DISTRICT COUNCIL
NORTH OXFORDSHIRE

Our Ref: 13/00321/OUT

Application under the Town and Country Planning Act 1990 for the following: OUTLINE - 1000 dwellings together with a local centre including retail (A1), financial services (A2), restaurants (A3-A5), up to a combined total floorspace of 1000m², employment space (B1) up to a total floorspace of 5000m² with the B1(a) office component limited to a maximum of 2,500m², associated car parking, a community primary school (including space for community uses (D1) and assembly and leisure uses (D2)), green infrastructure including formal and informal open space, amenity space, retained hedgerows, structural landscaping, supporting infrastructure (including gas, electricity, sewerage, water, telecommunications), sustainable urban drainage systems, new connection to the A361 Bloxham Road, pedestrian and cycling connections to the surrounding footpath and cycle network and any necessary demolition and ground remodelling

REQUIREMENTS UNDER REGULATION 22 (1) OF THE TOWN AND COUNTRY PLANNING (ENVIRONMENTAL IMPACT ASSESSMENT) REGULATIONS 2011 TO PROVIDE FURTHER INFORMATION IN RESPECT OF THE ENVIRONMENTAL STATEMENT

**FIGURE 8
 KEY SITE CONSTRAINTS**

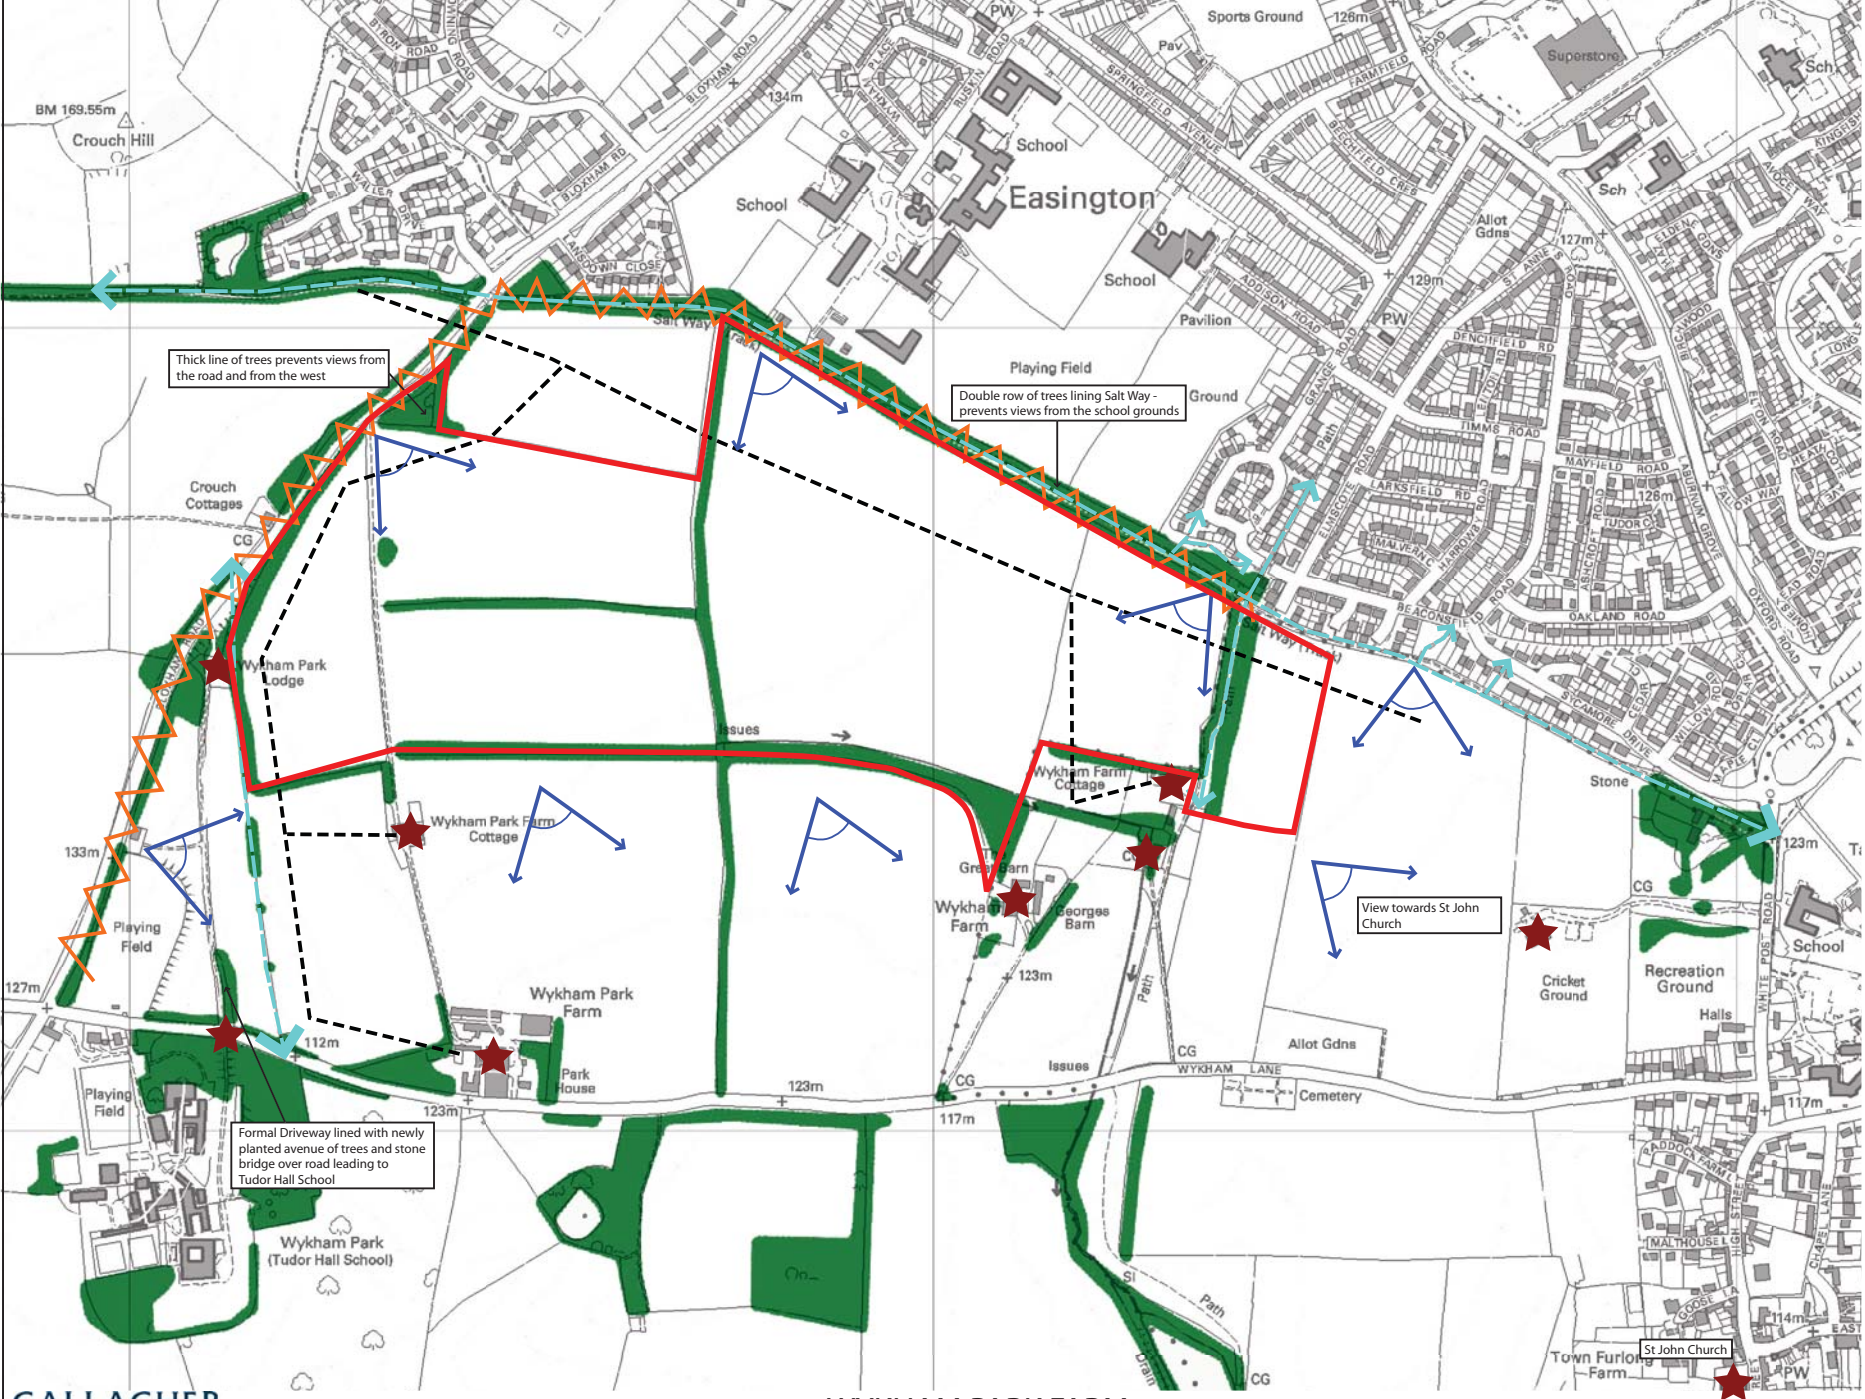
- 9.1.2. The LVIA does not adequately assess the historic landscape context of the site in terms of boundaries, land-use, field size and surviving features.

- 9.1.3. The non designated heritage features recognised in the walk over survey have not been added to the asset listing or mapping and are not fully contextually described or assessed.

# ILLUSTRATIVE DEVELOPMENT FRAMEWORK

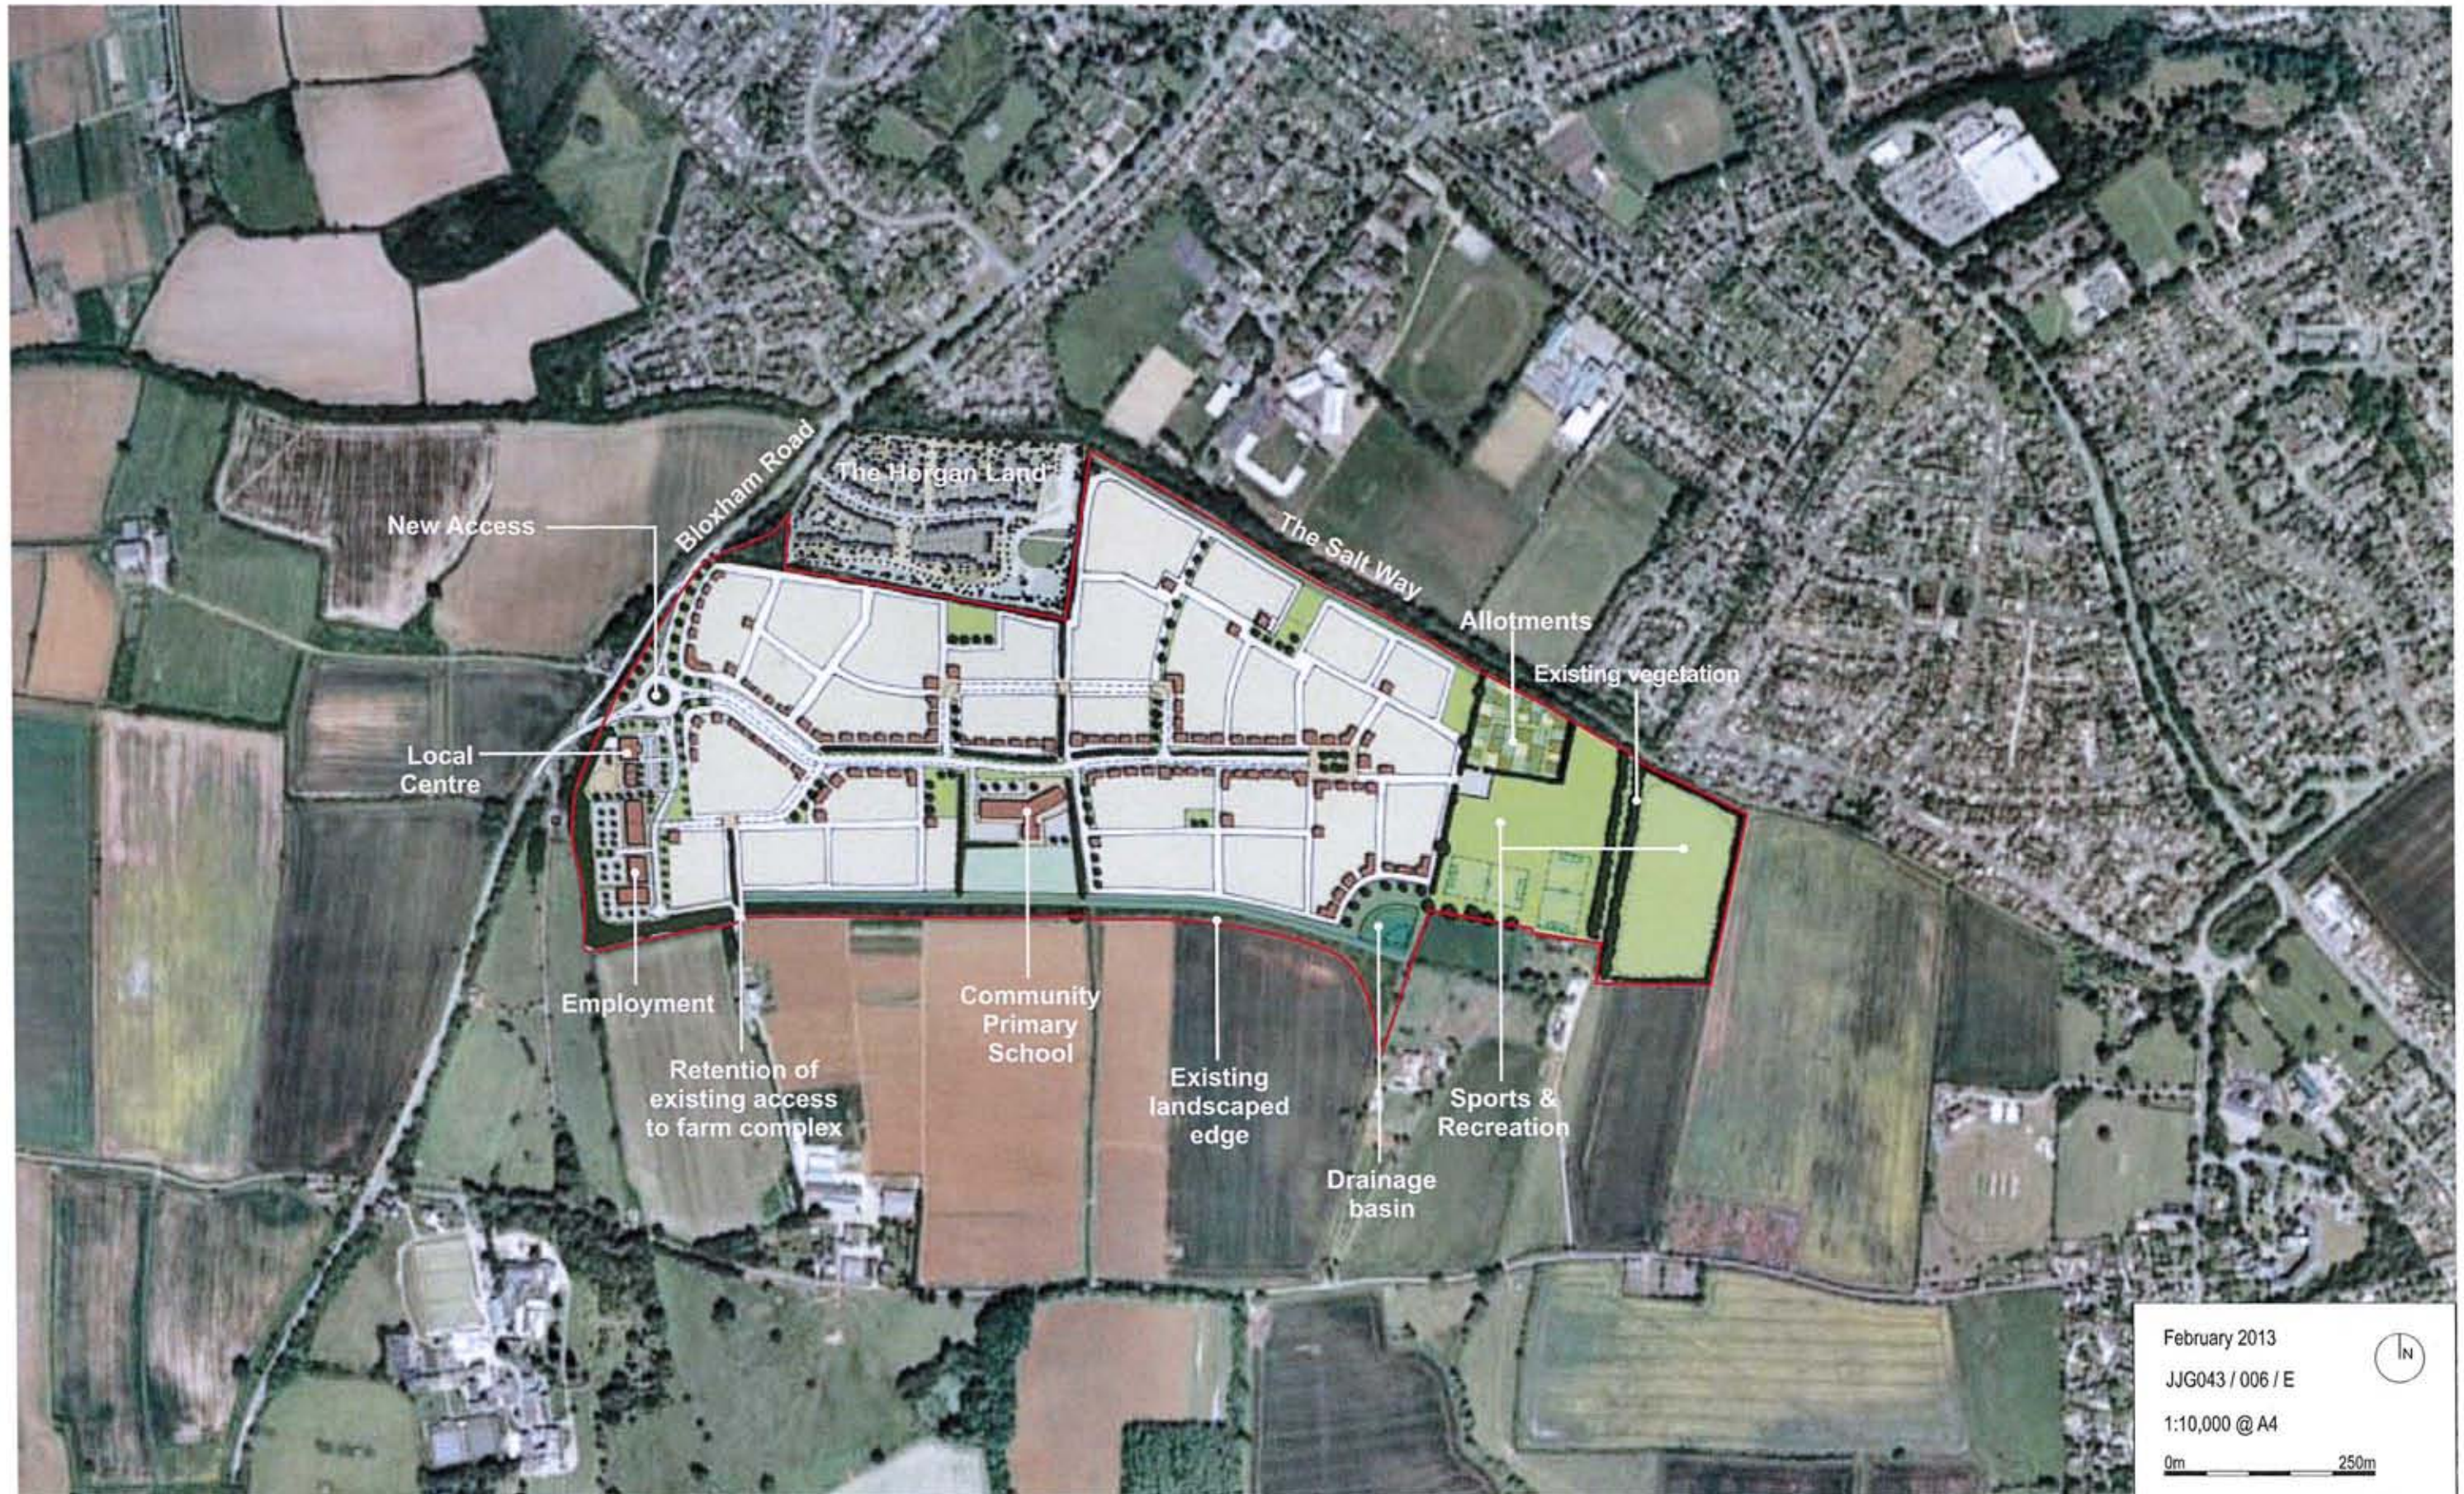
- 9.1.1. There are inconsistencies with the submitted DAS, parameter plan and the LVIA; the DAS clearly states that built form would be up to 12.5 metres in some locations, whereas the LVIA assessment is based on a built form of 10 metres across the site. Please clarify this discrepancy.
